**From:** Abiel X. Carrillo  
**To:** ["David Soule"](#)  
**Subject:** RE: C18D064B - Legacy NAA Apartments - Stamp Date 3/25/2016  
**Date:** Tuesday, May 10, 2016 11:13:00 AM

**From:** Abiel X. Carrillo  
**Sent:** Thursday, April 07, 2016 12:00 PM  
**To:** David Soule  
**Cc:** Cherne, Curtis  
**Subject:** C18D064B - Legacy NAA Apartments - Stamp Date 3/25/2016

Based on the information provided in your submittal received 3-24-2016, the above-referenced Grading and Drainage Report and Grading Plan cannot be approved for Preliminary Plat, Site Development for Building Permit, or Grading Permit. The plan can be approved for Site Plan for Subdivision, however, since it only involves the consolidation of the lots. The following sets of comments would need to be addressed prior to the applicable approval:

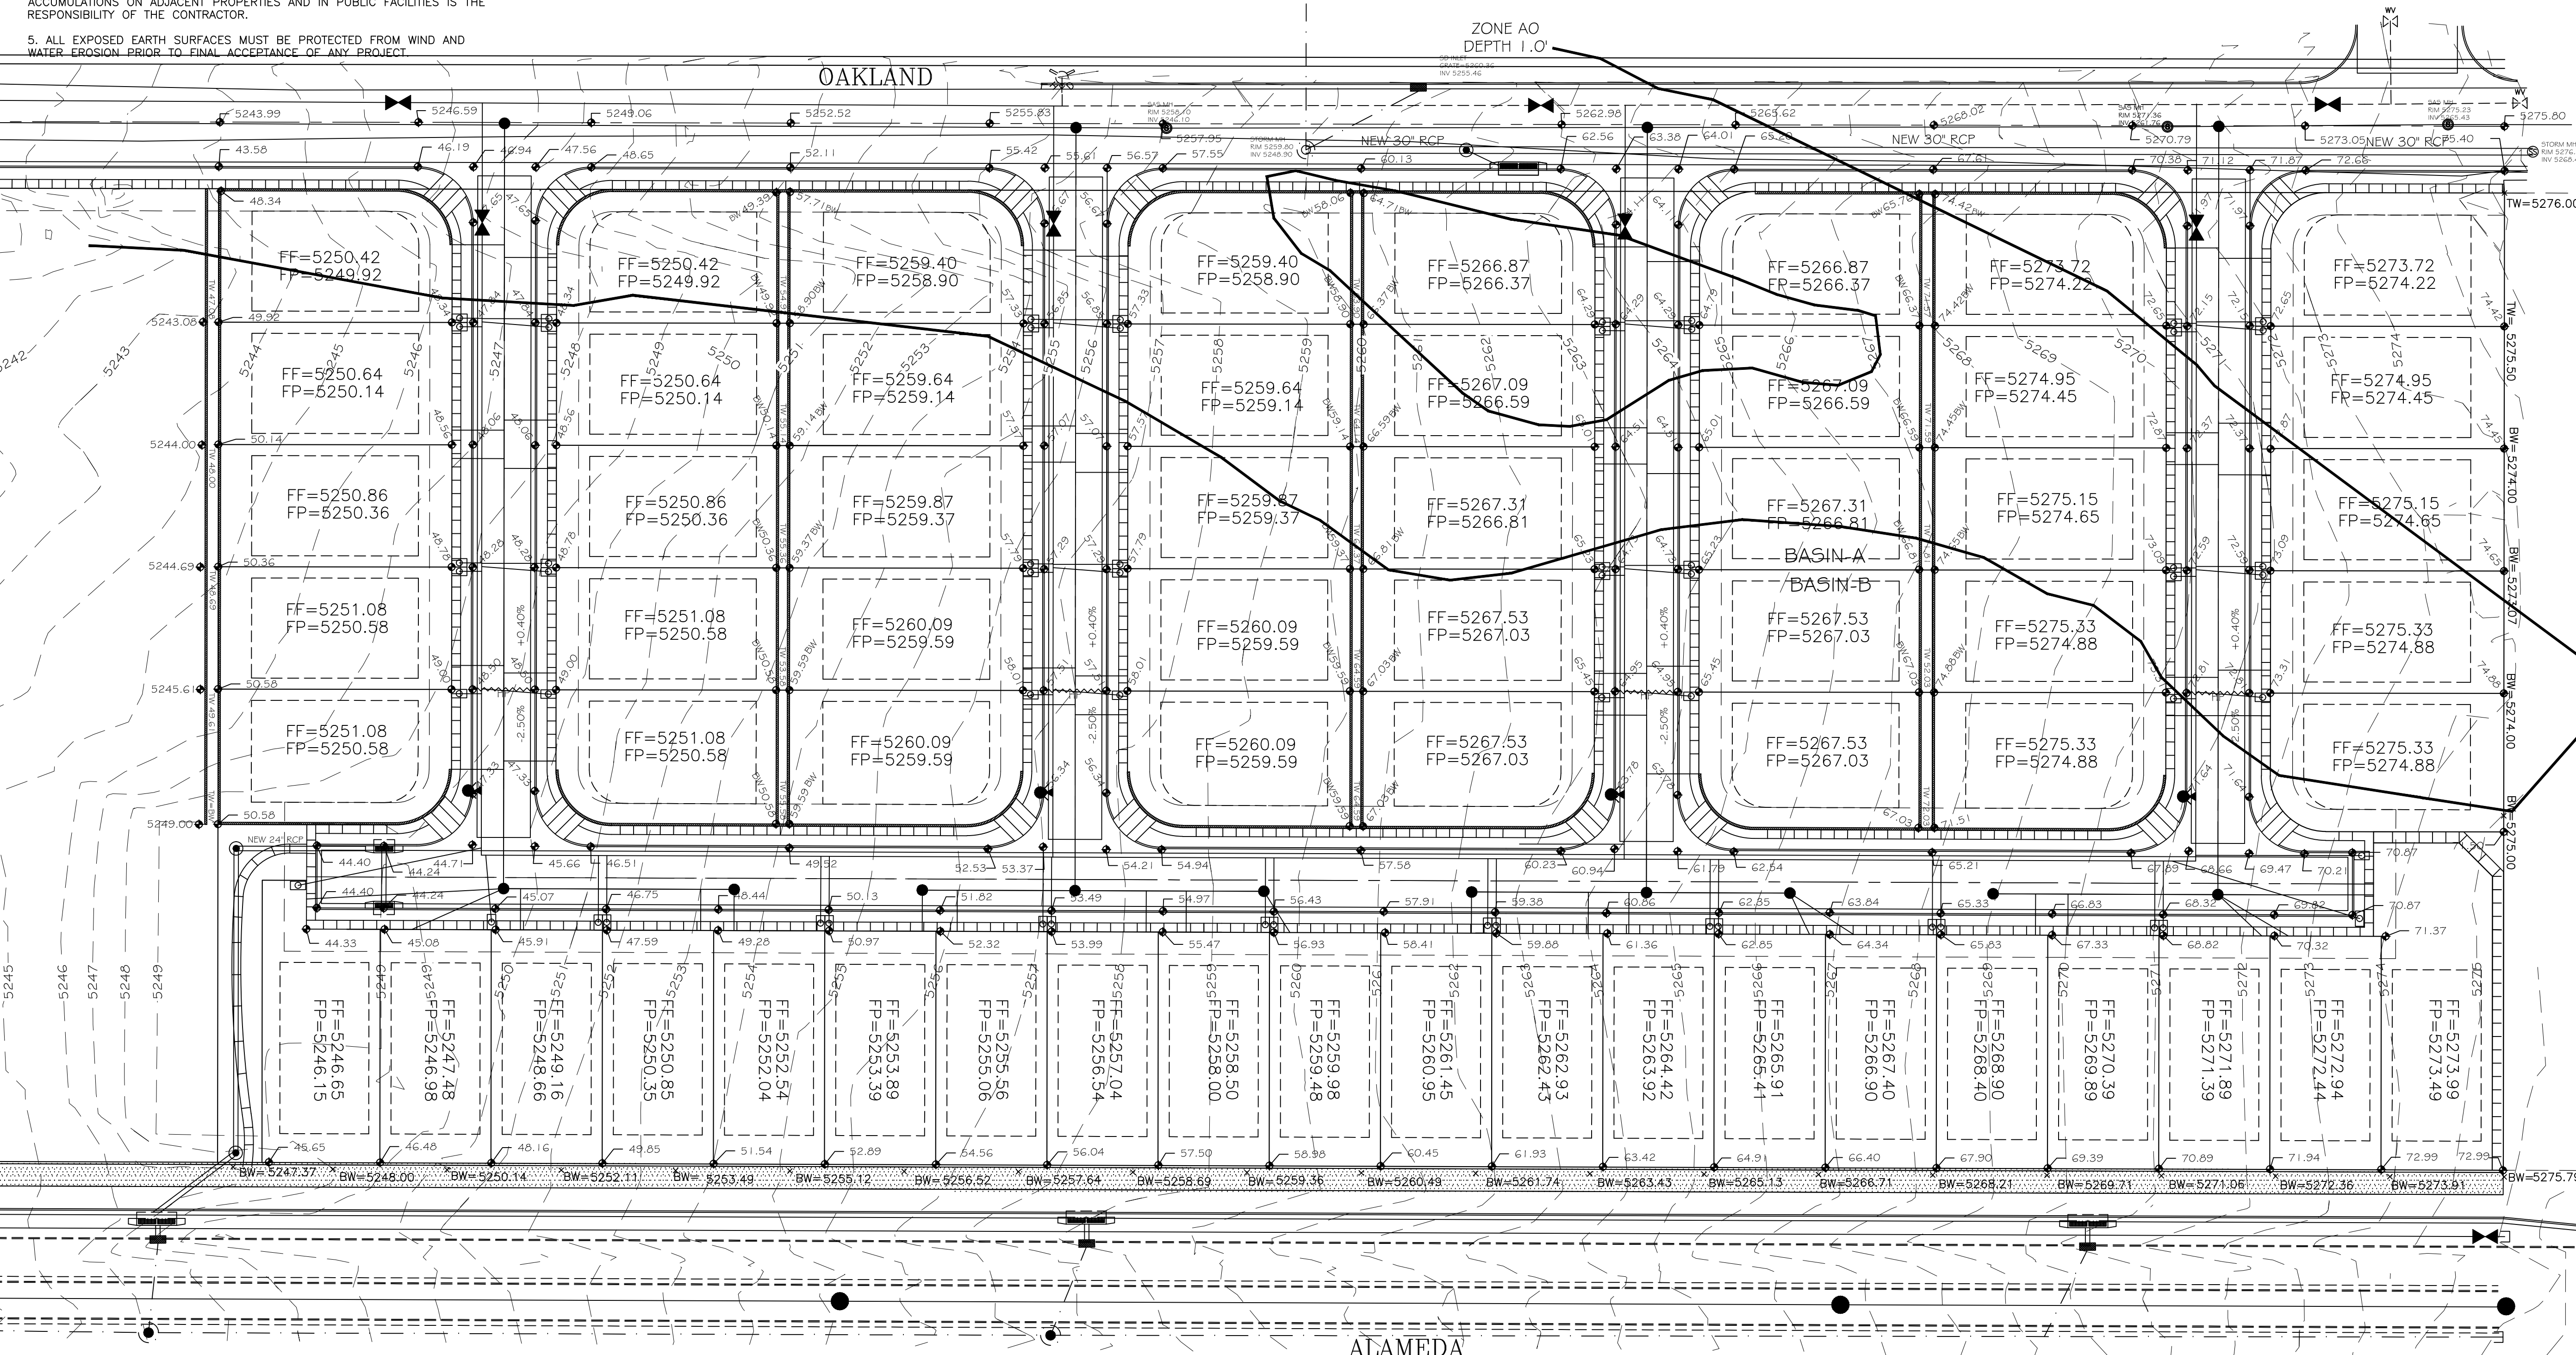
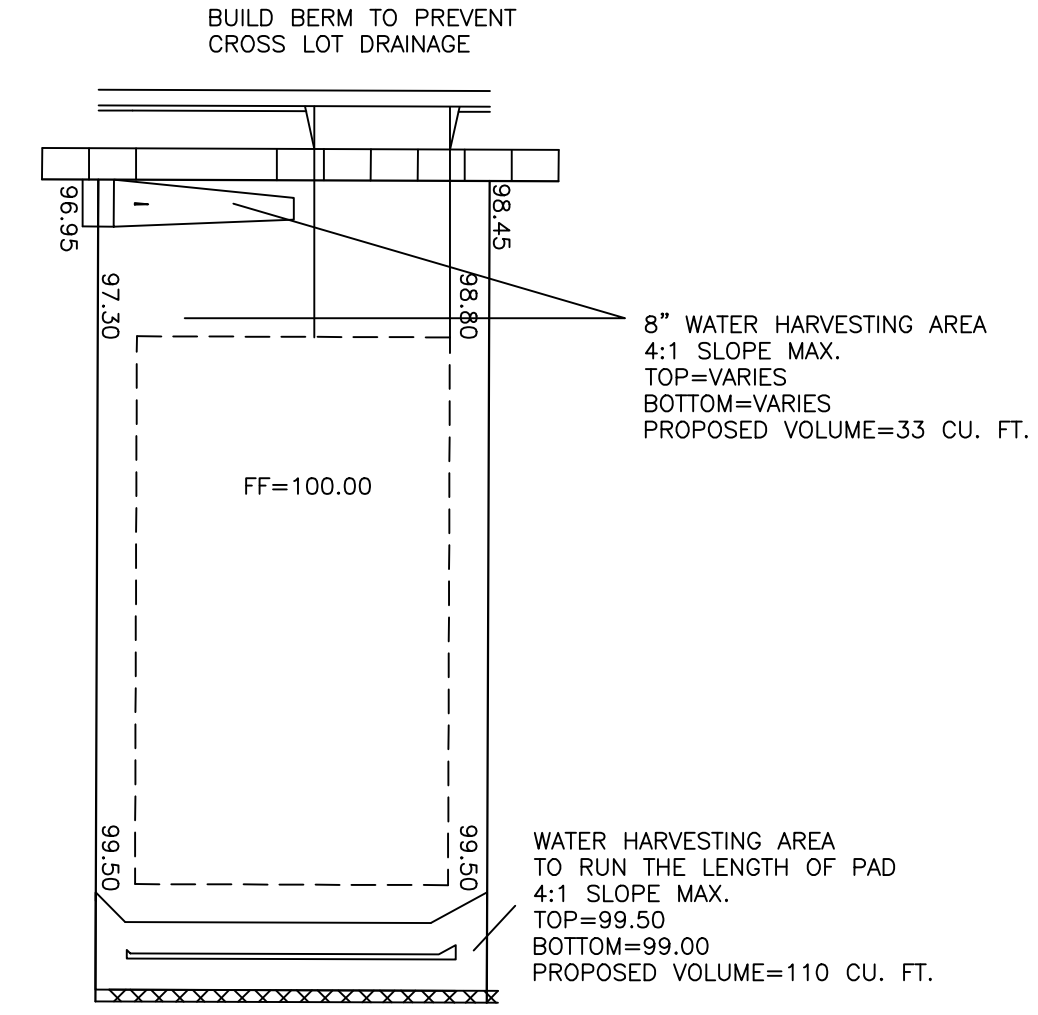
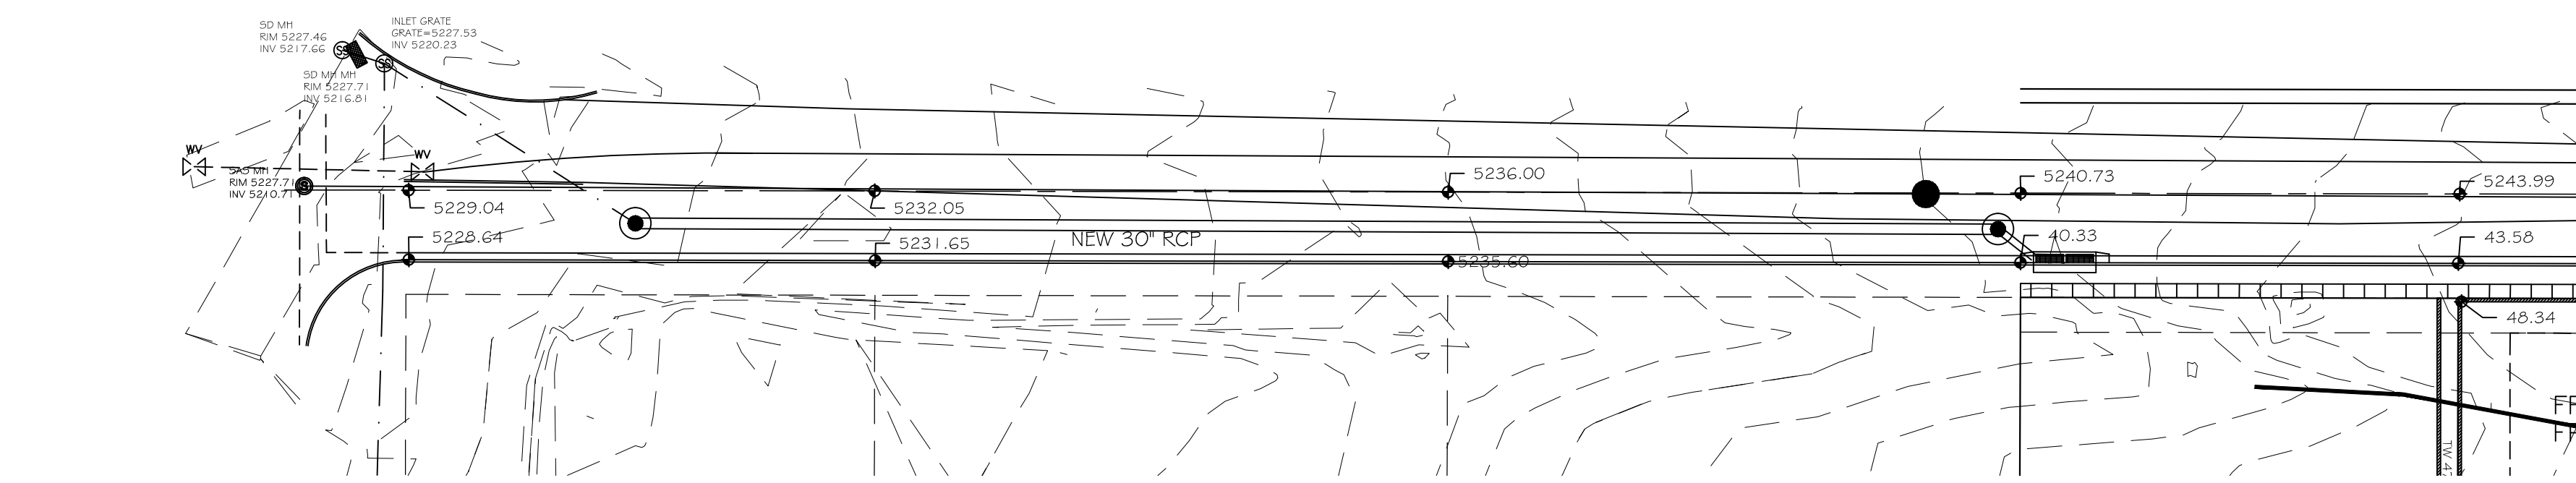
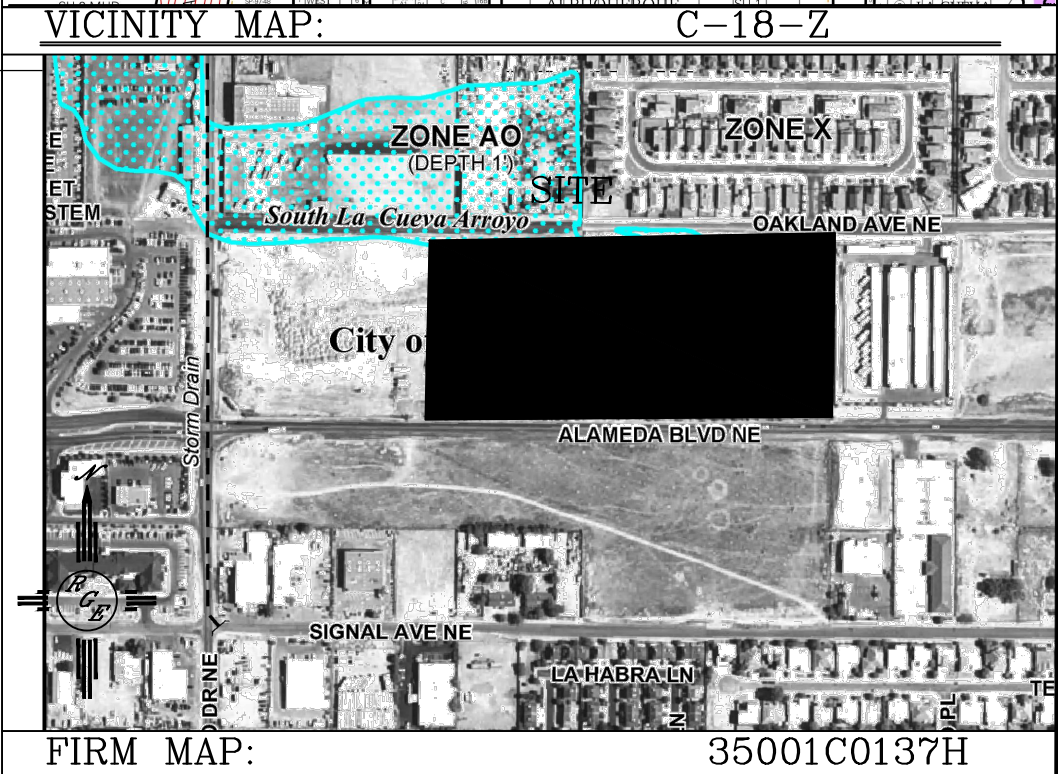
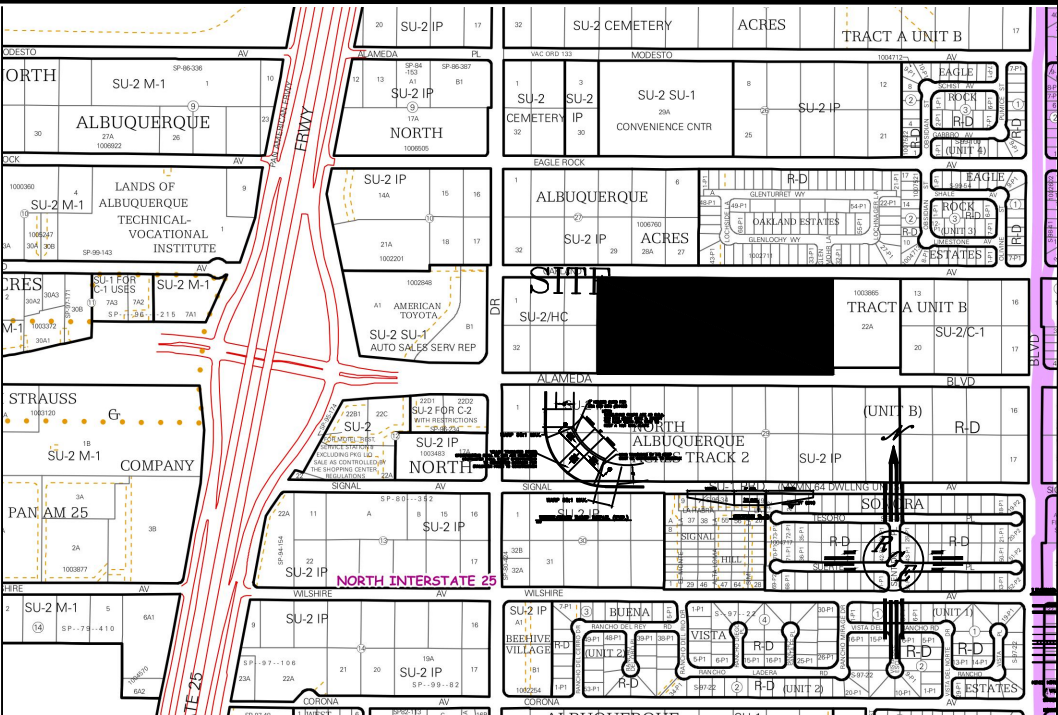
3. All pipes in the City Right of Way need to be either RCP or HPPP, the connection into the Oakland Ave Right of Way shows a 12" HDPE extension into the inlet. [The attached plan has the corrected rcp within the right of way](#)

1. An Erosion and Sediment Control Plan needs to be approved by the City's Stormwater Quality Engineer.
2. Provide a Benchmark for the project.
3. There appears to be a disconnect between the information in the Grading Plan and the analysis completed in the Report.
4. Describe the check dams that are called out (dimensions, etc), or show a detail on the plan.
5. Show the modified grate detail (DWG #2220) on the plan since it is not published yet.
6. In general, the pipe layout consists of 12" diameter pipes; it is not clear that the interior inlets need to be 30" and/or Double D grated.

7. Provide a cross-section for the typical installation of the inline drains near the top of the first flush ponding areas. The typical detail provided is a general layout from the product catalog.

8. Clarify the distribution of discharge to the three outlet points by labeling the discharges on the Basin Map to facilitate future research of this project. Provide a full size Basin Map as a part of the Grading Plan.

9. Consider using drop manholes just before the outlets instead of laying the entire interior pipe network so deep (8'+). It may be difficult for the Owner to maintain deep, 12" lines that have Tee connections.

Abiel, please find the attached revised infrastructure list and site plan package, We have added additional inlets to the existing stubs and provided RCP to all the inlets in the right of way. We are having weekly design meeting with the architect so some of the grading will be slightly adjusted and we will submit the report in accordance with your additional comments below. Thank you very much  
David Soule  
Rio Grande Engineering  
321.9099
